Arun District Council
Arun Civic Centre
Maltravers Road
Littlehampton
West Sussex BN17 5LF
Planning & Building Control General Enquiries
Tel: (01903) 737756 Fax: (01903) 730442
Dx: 57406 Littlehampton
Minicom: 01903 732765
e-mail: planning@arun.gov.uk
website: www.arun.gov.uk/planning

Application No: K/40/20/HH
Site Address: Panorama Golden Acre Kingston BN16 1QP
Description of works: Single-storey extension with a sloping roof, new porch on ground floor and conservatory at first floor. Replacement of existing windows, doors and roof tiles.

Thank you for your internet representation made on 6th November 2020 which has been recorded as an objection with the comments as follows:

DRAWING No.
220

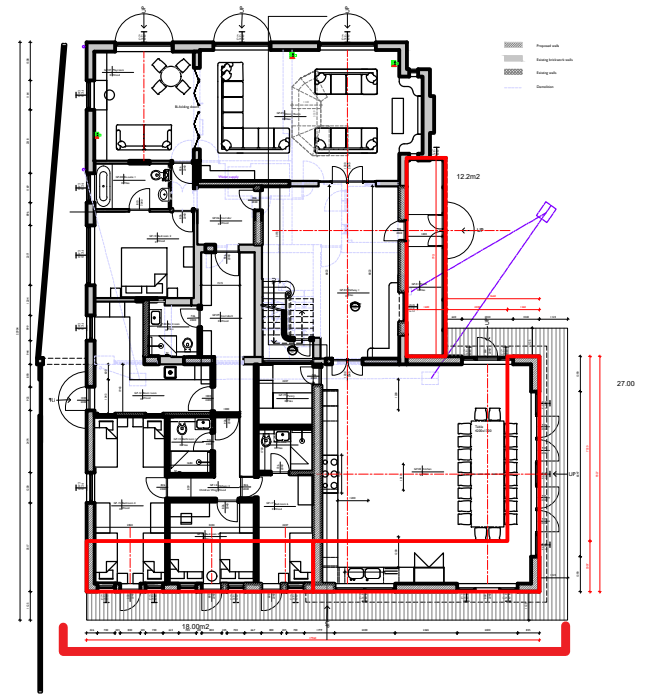
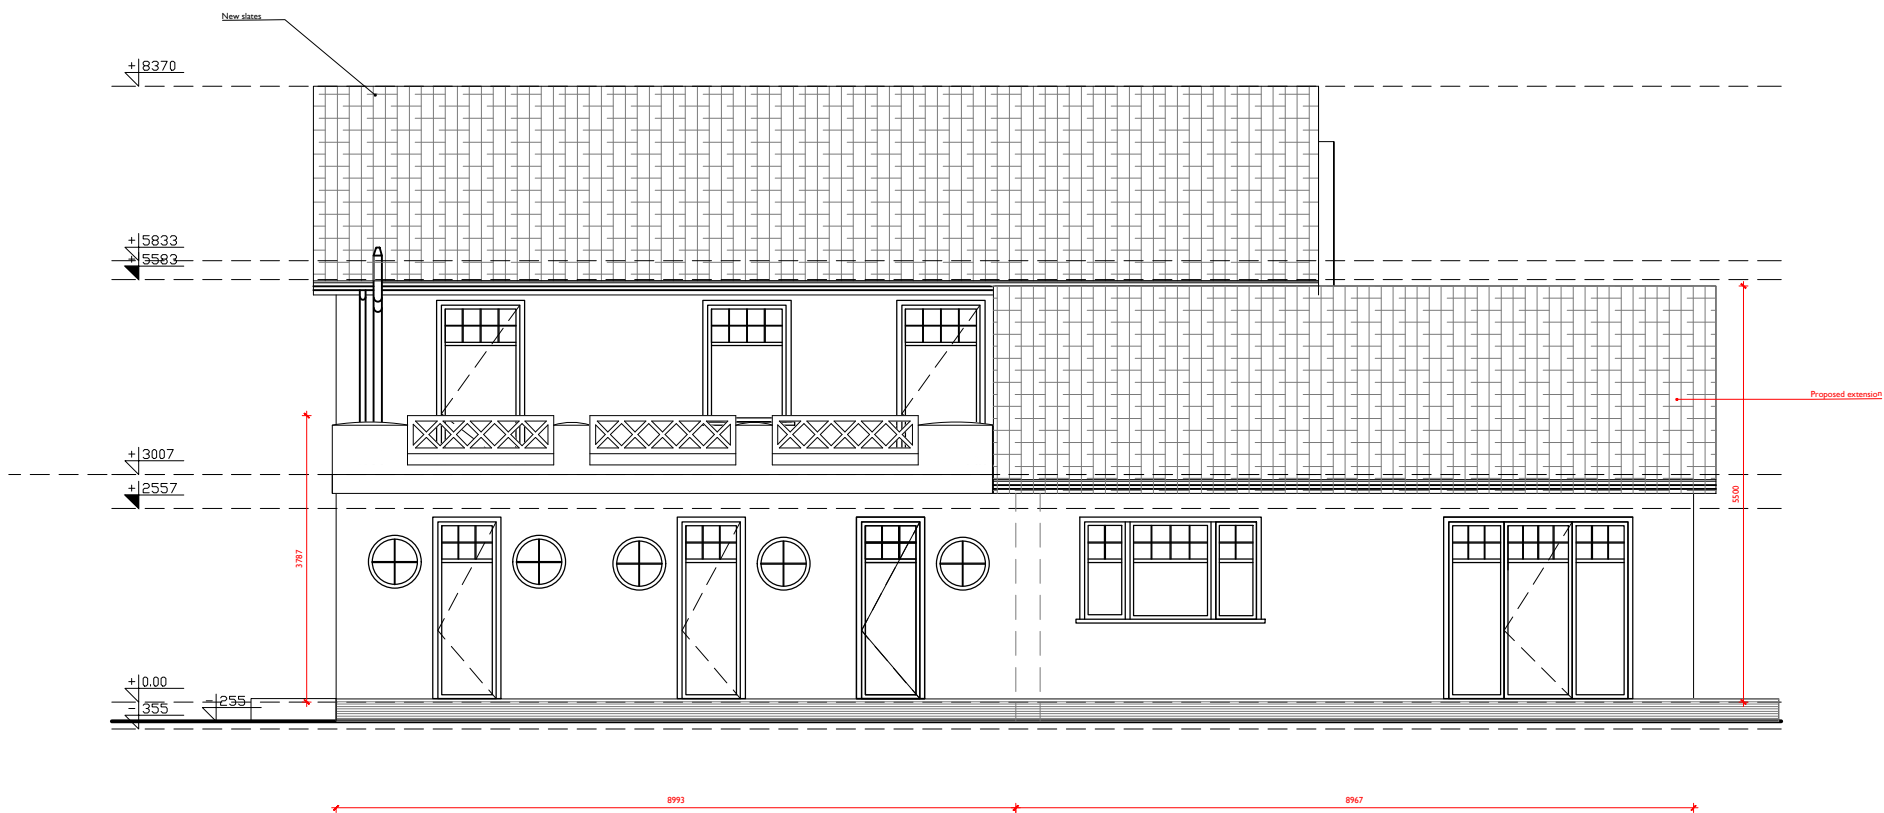
We are objecting to the latest proposal on the grounds of loss of privacy and increased noise especially with the inclusion of the 'party' roof terrace. (see drawings 220,221,221a etc) on the basis that:-

- 1) Our rear garden and bedrooms will be overlooked.
- 2) The increase in noise being emitted from an elevated position will be more audible into our bedroom space and especially invasive during the long Summer evenings when the applicants will be hosting their guests from this area. This will be amplified by having to keep our windows open at night during hot weather.

TITLE
EXISTING
SITE LOCATION PLAN
BLOCK PLAN

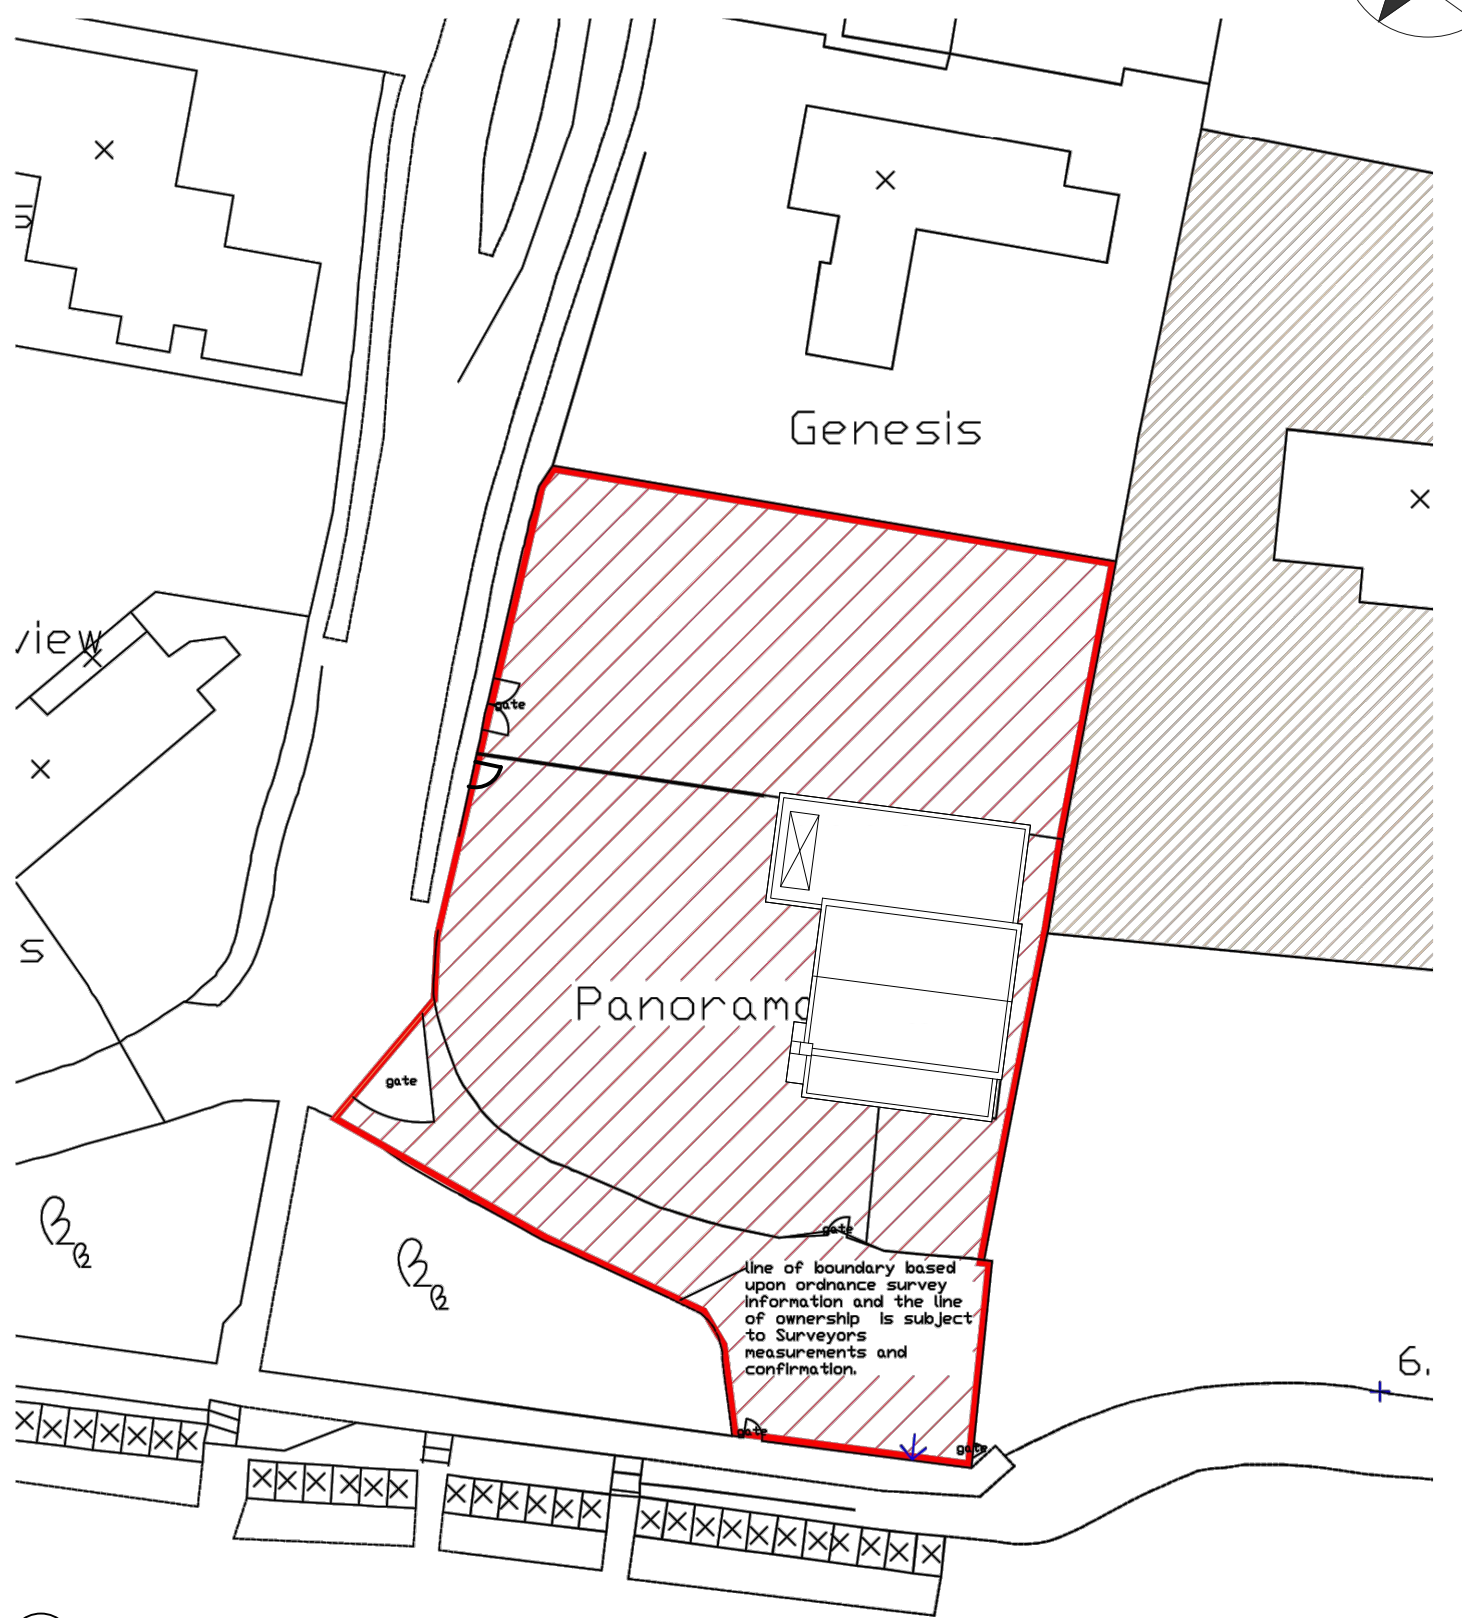
The Plan View drawings and Location drawings submitted omit the presence of our property, which is in fact, the nearest property and is to the East of Panorama. Our property immediately backs onto Panorama and is much closer than that declared in the applicant's Planning Statement. This erroneously states that the nearest neighbour to Panorama is to the North.
